# Immingham Green Energy Terminal

## 10.6 Proposed Change Application Report

May 2024

Document Reference: TR030008/EXAM/10.6

Site Boundary & Works Plans Changes between DCO Application (September 2023) & Change Application (March 2024) Key Plan

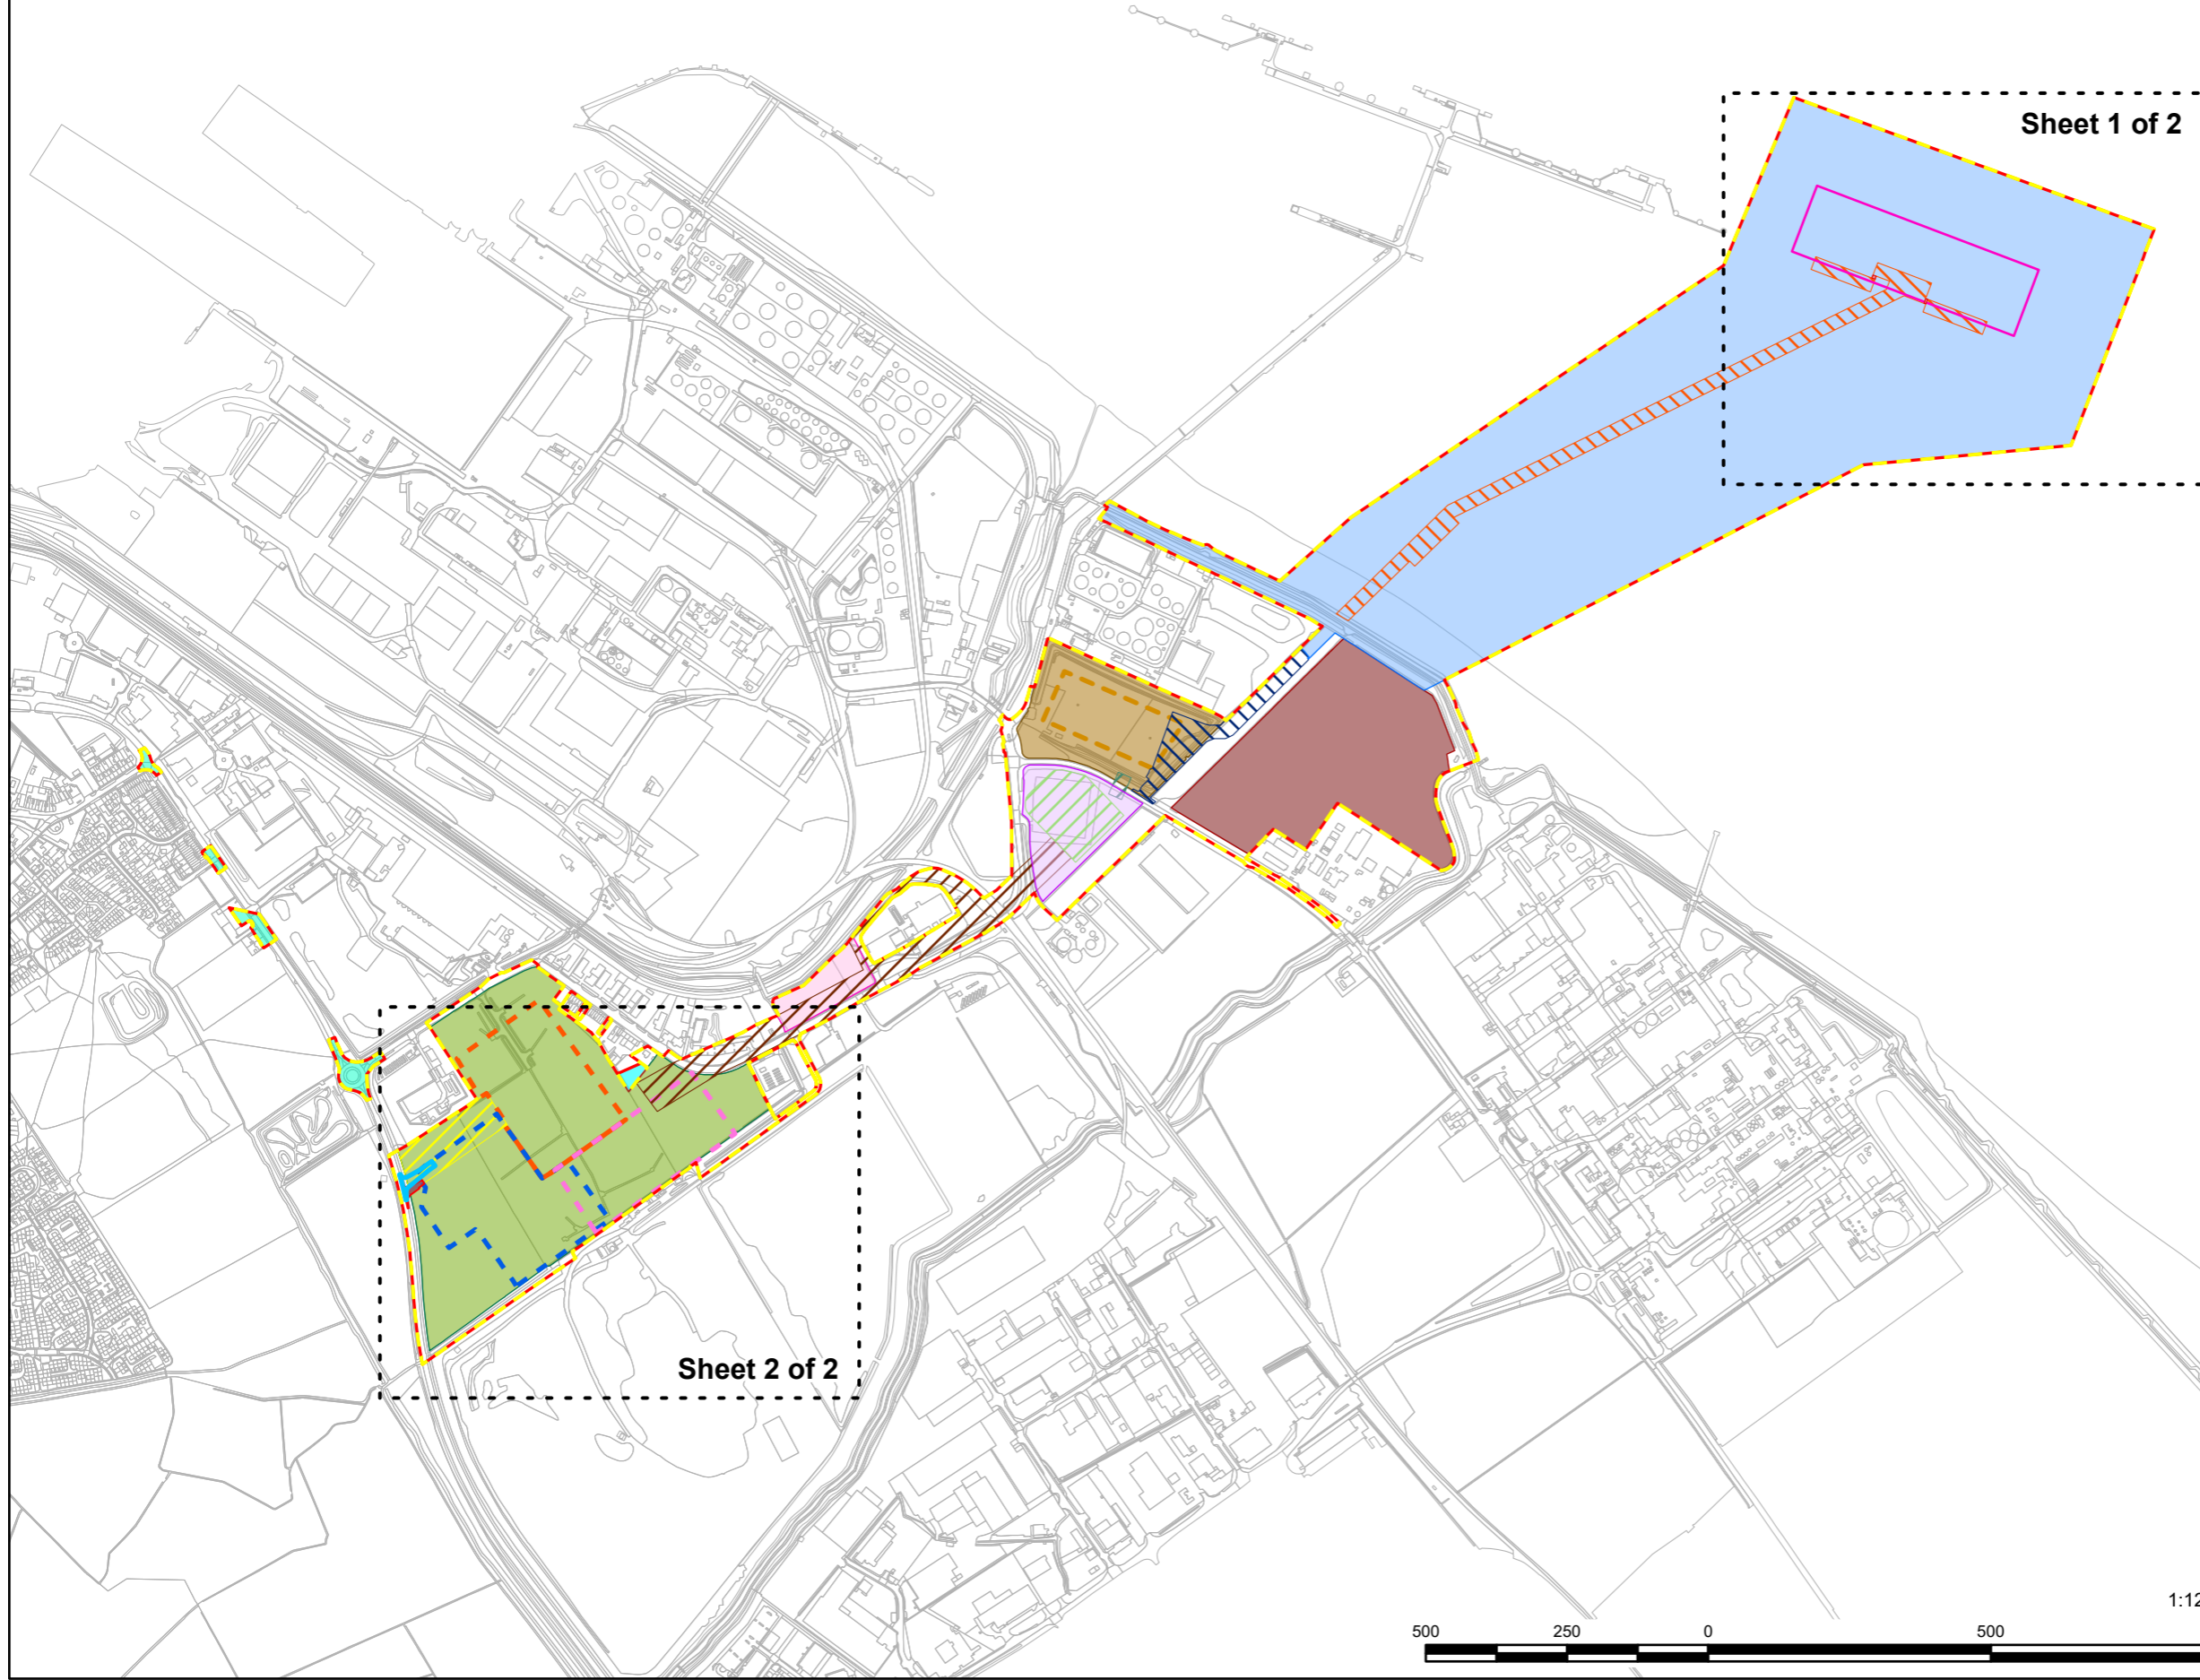
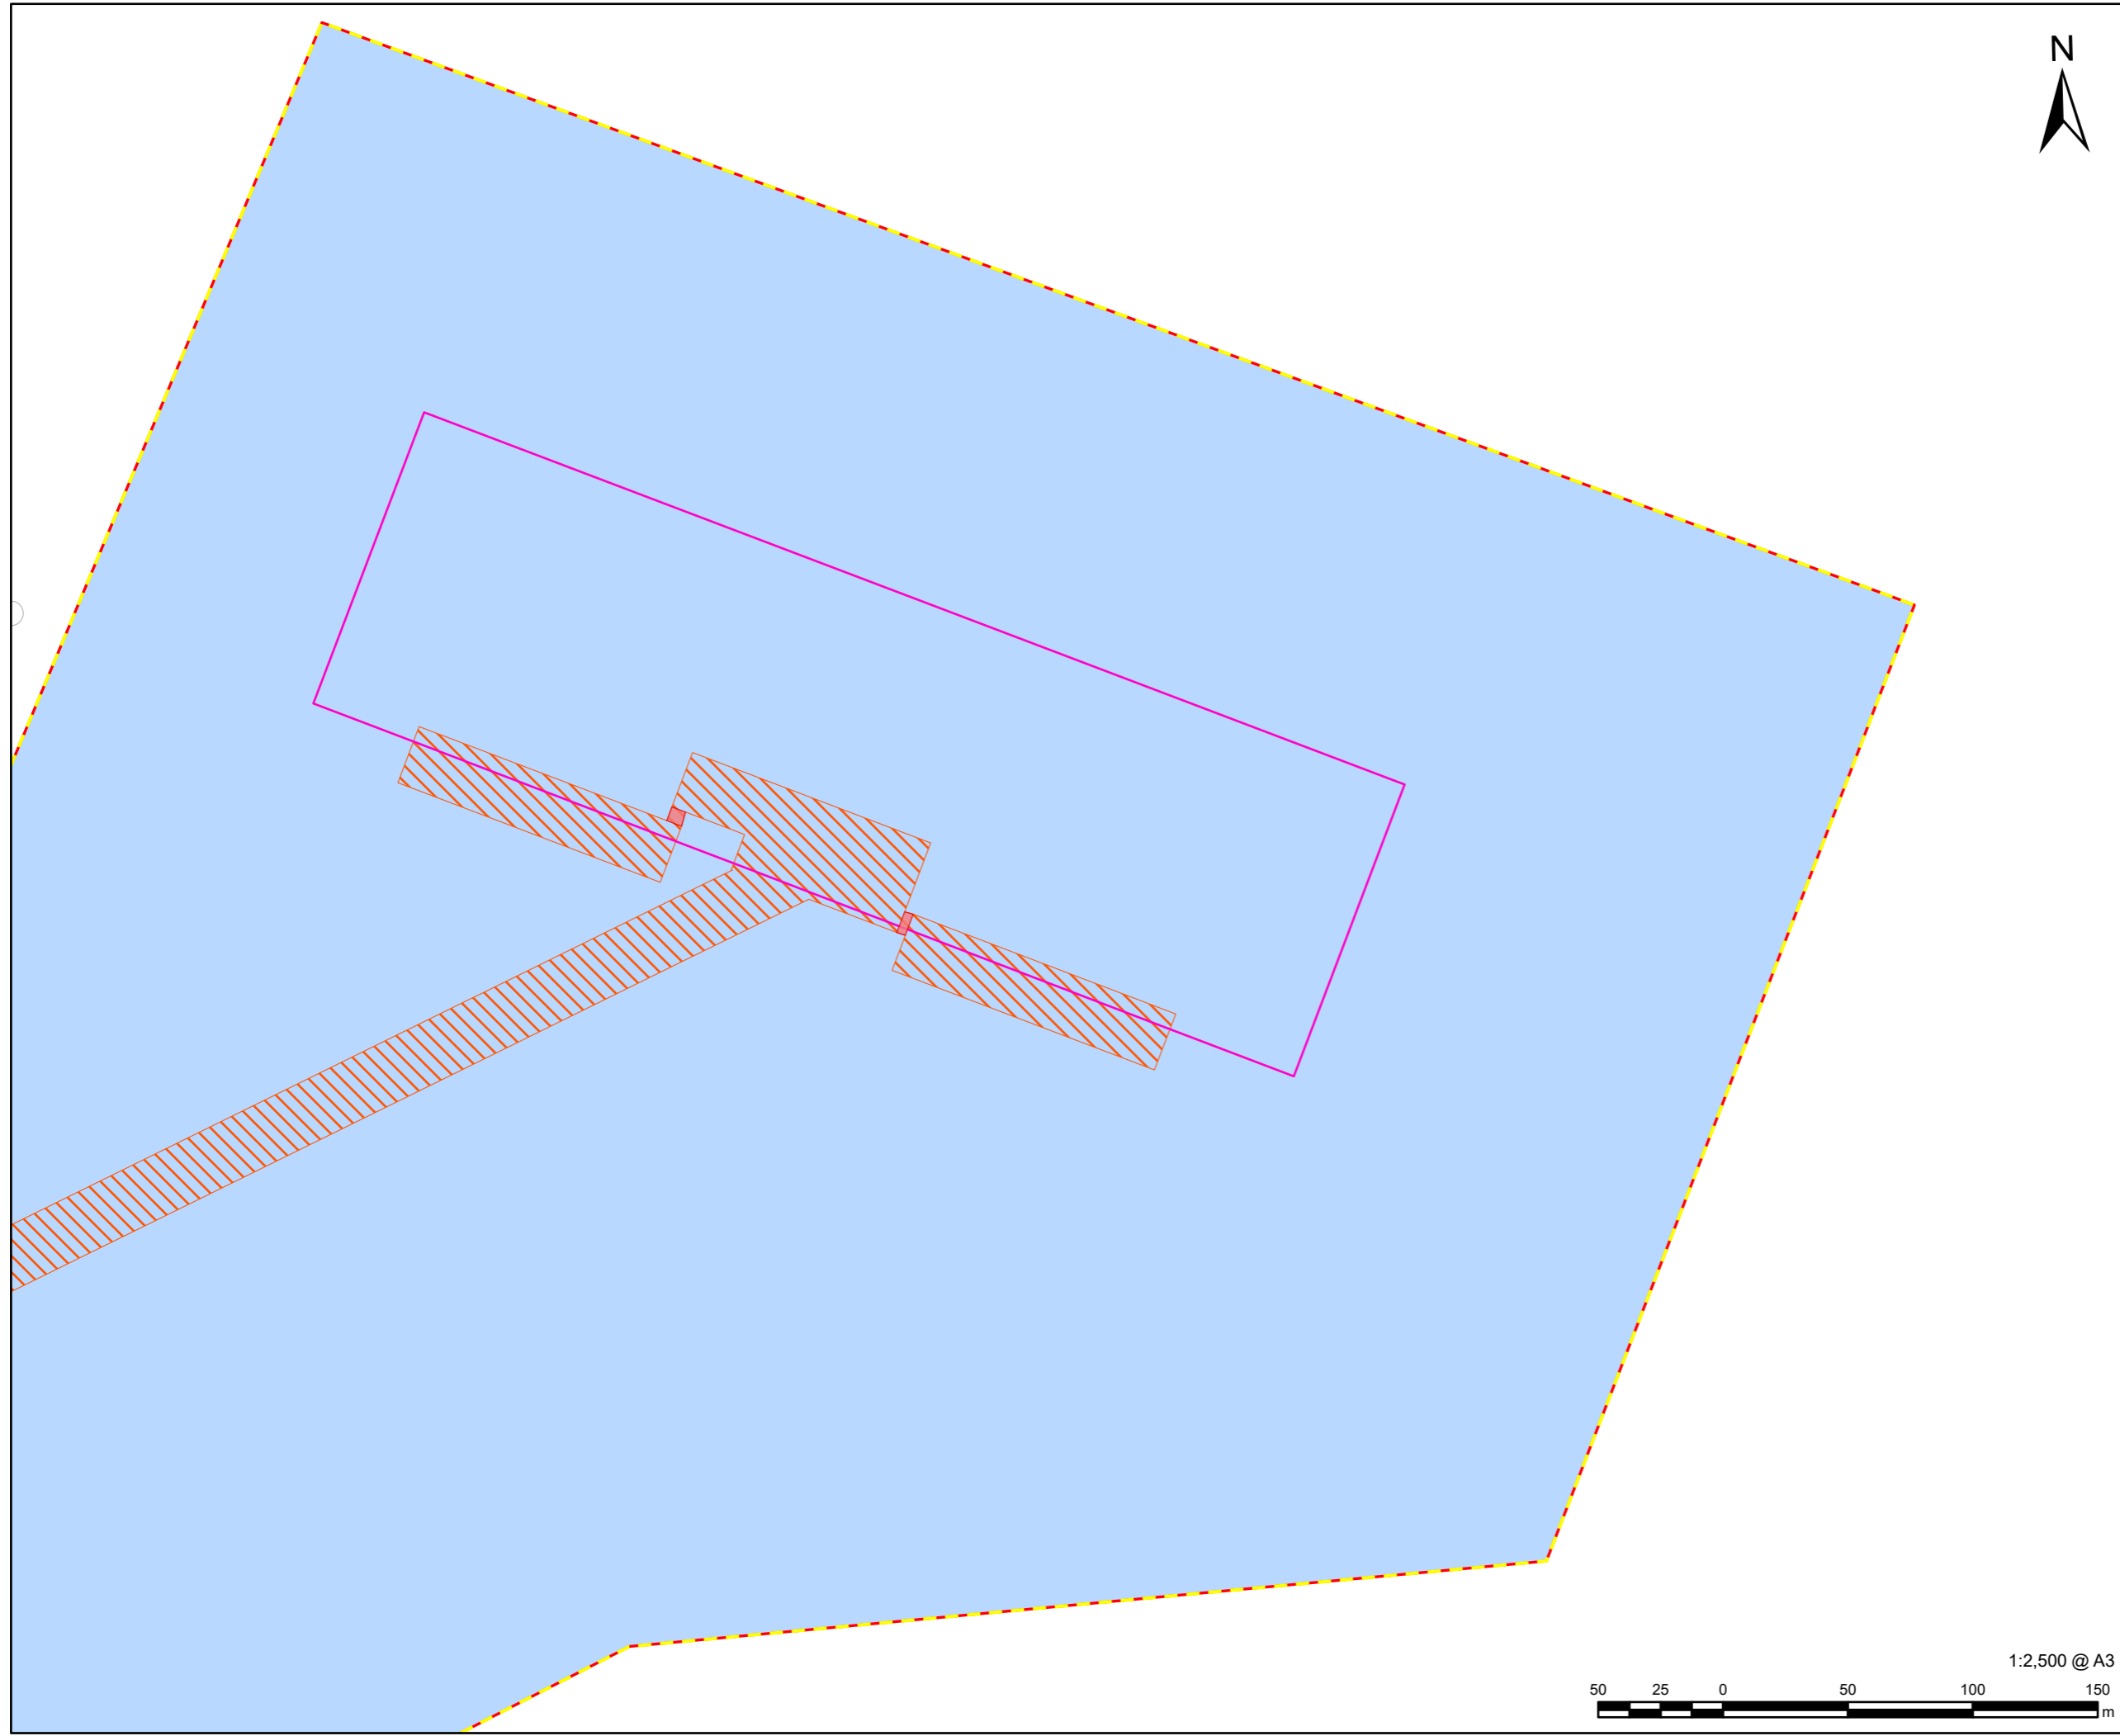
- 2.4.1 Proposed Change 3 comprises minor changes to the northern access from the A1173 to Work No. 7 (marked “AB” on the **Street Works and Accesses Plan [TR030008/APP/4.6(2)]** and referred to as “Access AB” below) and amendment of the Order Limits (red line boundary) at the eastern edge of Work No. 7 to include additional land for temporary construction purposes.

- 2.4.3 Proposed Change 3 requires the extension of the Order Limits to include a small area of additional land to the east of Work No. 7. The inclusion of this land is for the purposes of construction, and therefore powers of temporary possession are sought in respect of this land, rather than powers of compulsory acquisition. As a result, the CA Regulations are not triggered by this Proposed Change 3 (further detail on this set out in **Section 7** of this Report).. Proposed Change 3 does not require an amendment to the **Outline Construction Environmental Management Plan [TR030008/APP/6.5(3)]**.

- 2.4.4 Proposed Change 3 also includes minor changes to Access AB. As a result of the slight shift of the likely layout of the hydrogen production facility, Access AB needs to be adjusted by approximately 10–15 metres to the north-west.

- 2.5.2 The visual addition of the walkways in the **Works Plans [TR030008/APP/4.2(3)]** is shown indicatively in **Figure 5** below and on **Sheet 1 of 2** in **Appendix 4**.
